Our ref: AN/2023/134135/03-L01
Your ref: TR030007
Date: 5 September 2023

Application by Associated British Ports for an Order Granting Development Consent for the Immingham Eastern Ro-Ro Terminal – Deadline 2 submission

Figure 7.19

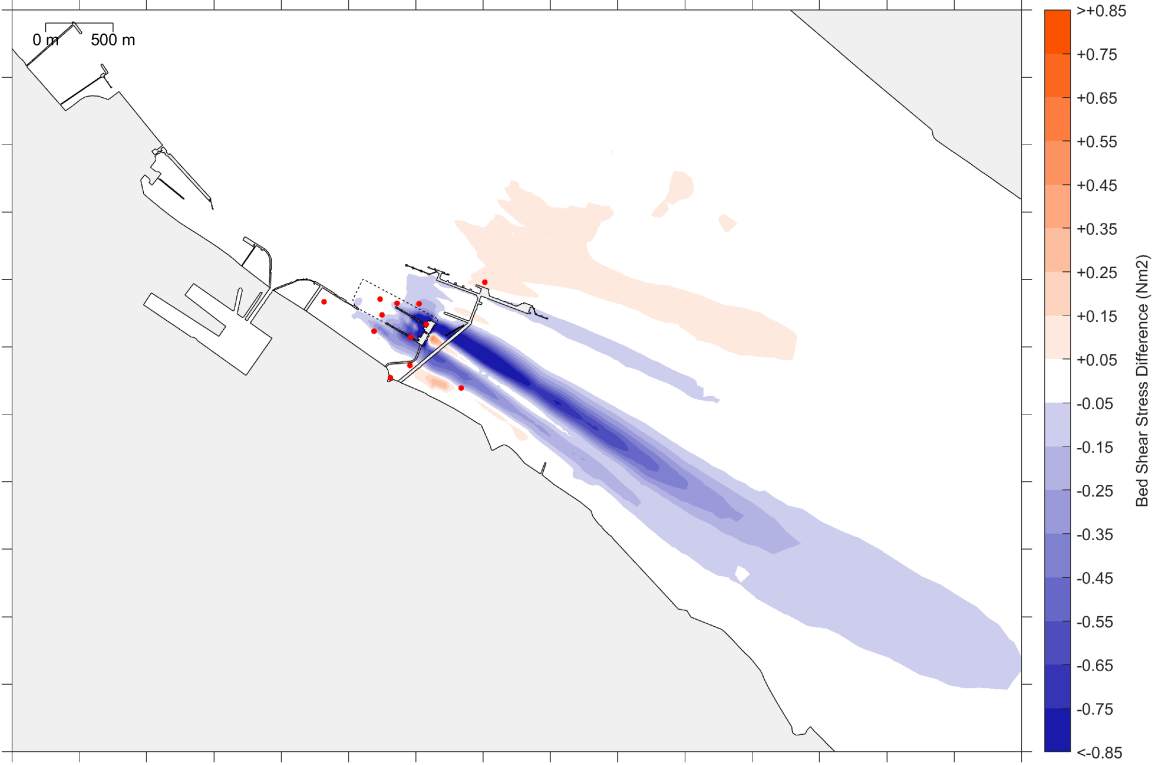
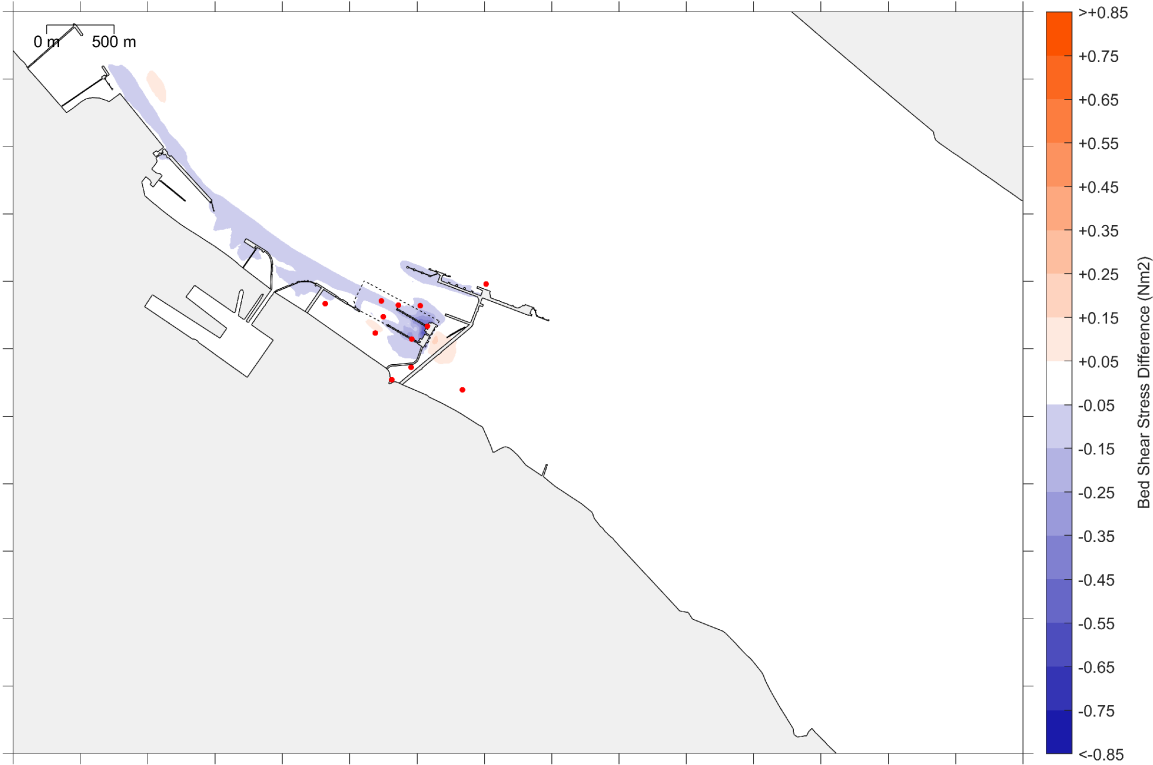
2.1 The Applicant has provided additional information which satisfies our concerns and explains the ‘undefined value’. However, we would reiterate that although we did manage to interpret the diagram with inverted topography/bathymetry and are aware of such issues, other readers of this information, may not be so aware. Others may also not be so familiar with the area and will need the north arrow, scale bar etc. to enable them to orient themselves. In respect of the “undefined value”, the label could be changed to reflect what it is intended to represent, i.e. “area exposed at high water” or “area above normal high water”.

2.2 It is our view that in the interests of open and transparent consultation, alongside the Environmental Statement becoming a ‘certified document’ under Article 33 of the DCO, these figures need to provide an accurate representation of the assessment made and should, therefore, be revised. However, we will leave this to the discretion of the Examining Authority to decide if this is required.

To assist with interpretation, Profile line A-A' (Figure 15; Appendix 7.2) and Profile line B-B' (Figure 16; Appendix 7.2) both run approximately northwest to southeast; and Profile line C-C' (Figure 17; Appendix 7.2) runs approximately south-southwest to north-northeast. Lastly, within figure 7.19 (volume 2), there is no evidence to indicate that the IERRT project has the potential to cause any meaningful change to bed thickness at the base of the existing defences. Where the 'undefined value' is shown on this figure, this represents a region of the model that is exposed at the tidal state shown (i.e. there is no water in the model at this location at this timestep). Regardless of tidal state, there is only predicted to be changes to bed thickness within the coloured regions shown on Figure 19 (Volume 2).
